Your ref: MP10_0125
File no: MC-05-114/3

3 February 2011

**Coca Cola Amatil's Distribution Centre, Eastern Creek
Plastic Manufacturing Facility, MP10_0125**

Figure 6: Site layout and proposed manufacturing facility

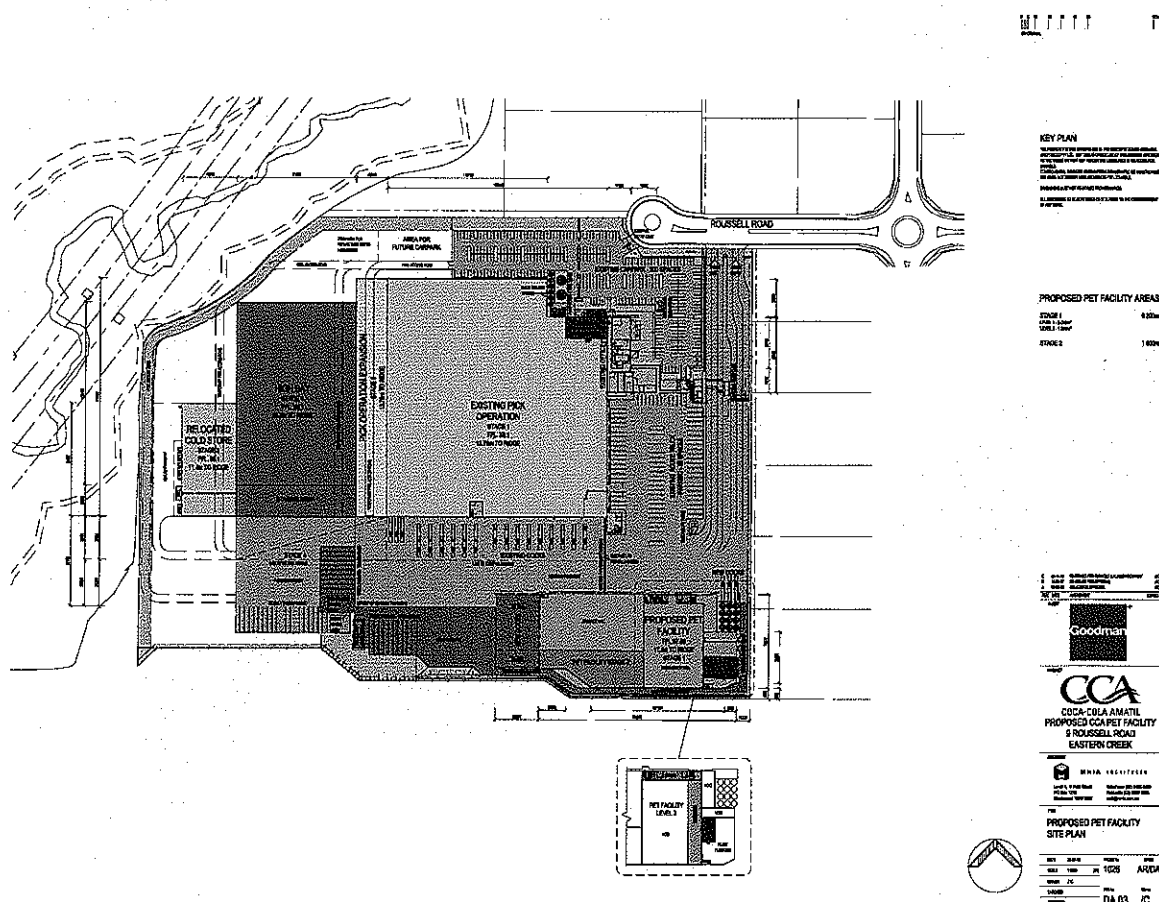
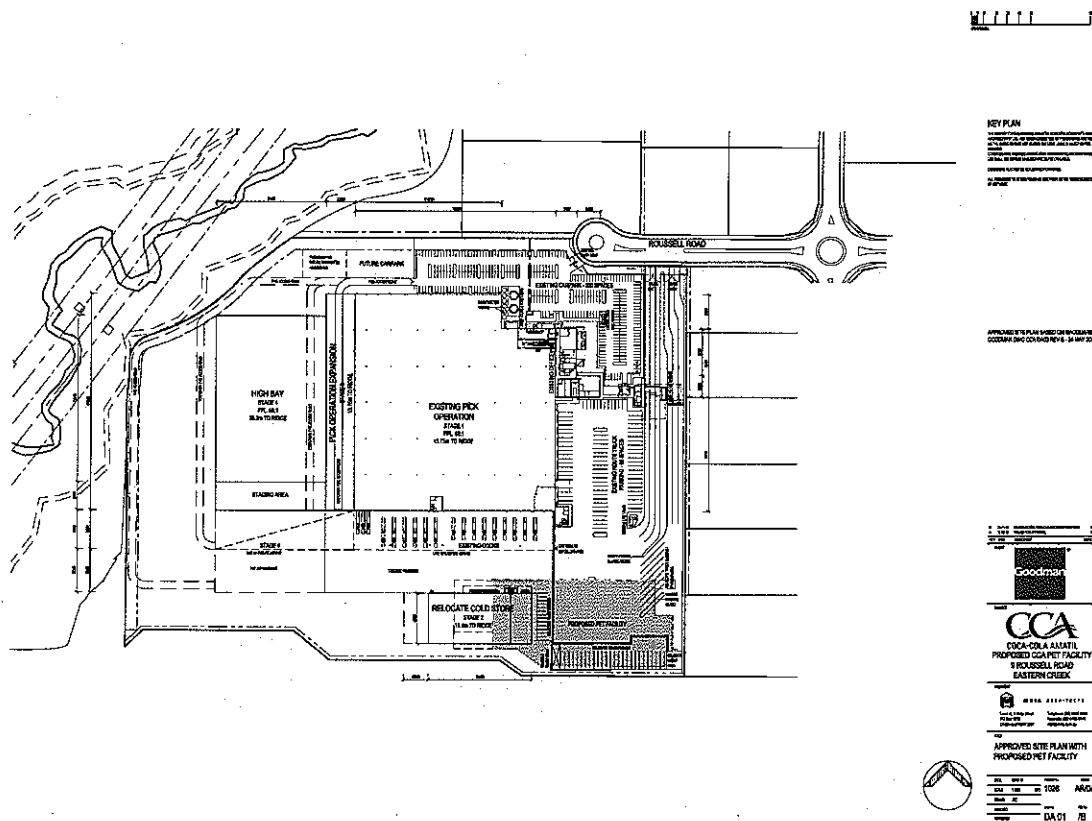
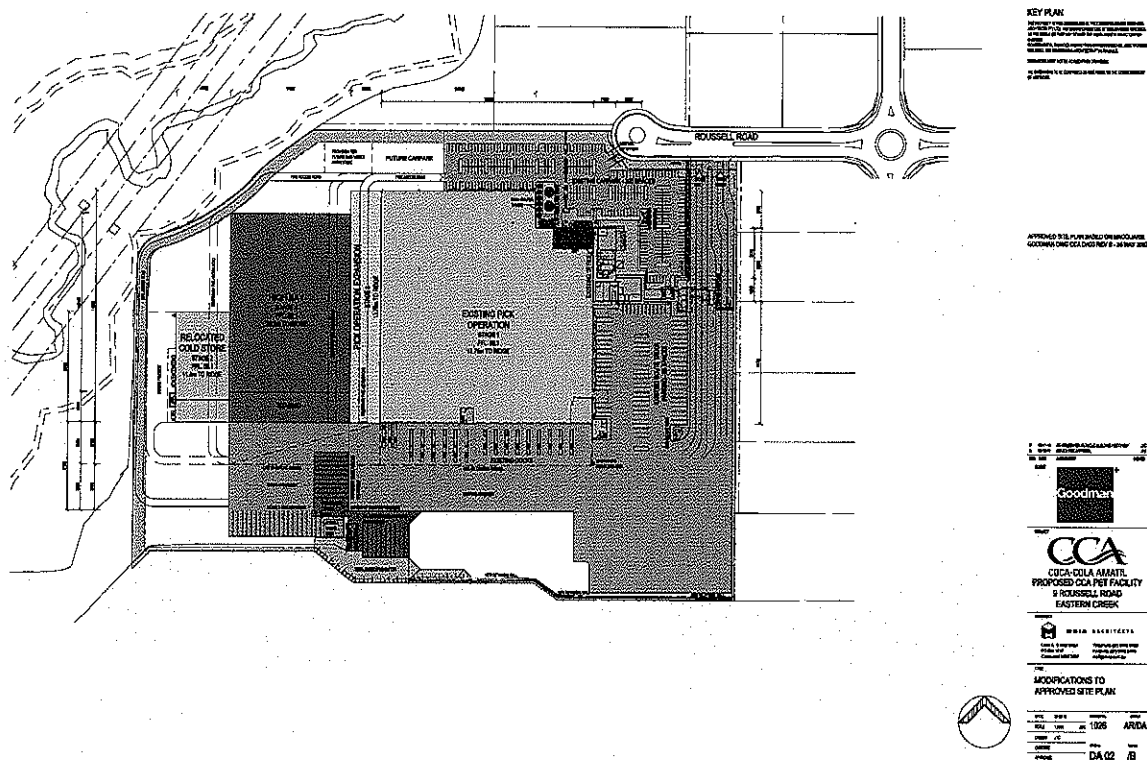
Consideration should be given to provision of additional on site car parking spaces to accommodate the increase in floor area on the site. SEPP 59 – Eastern Creek Precinct Plan (Stage 3) provides the following car parking requirements:

Accordingly an increase in the overall GFA of the site of 10,000sqm would generate a requirement of 87.5 spaces. No additional parking is provided on site (with the exception of an indication that a future car park is proposed adjoining the existing car park for 300 spaces).

The applicant has failed to adequately demonstrate that the site has sufficient on site car parking, the submitted statement states *“matters relating to Traffic and Transport, including parking, were largely addressed during prior industrial estate and / or subject site approvals and development”*.
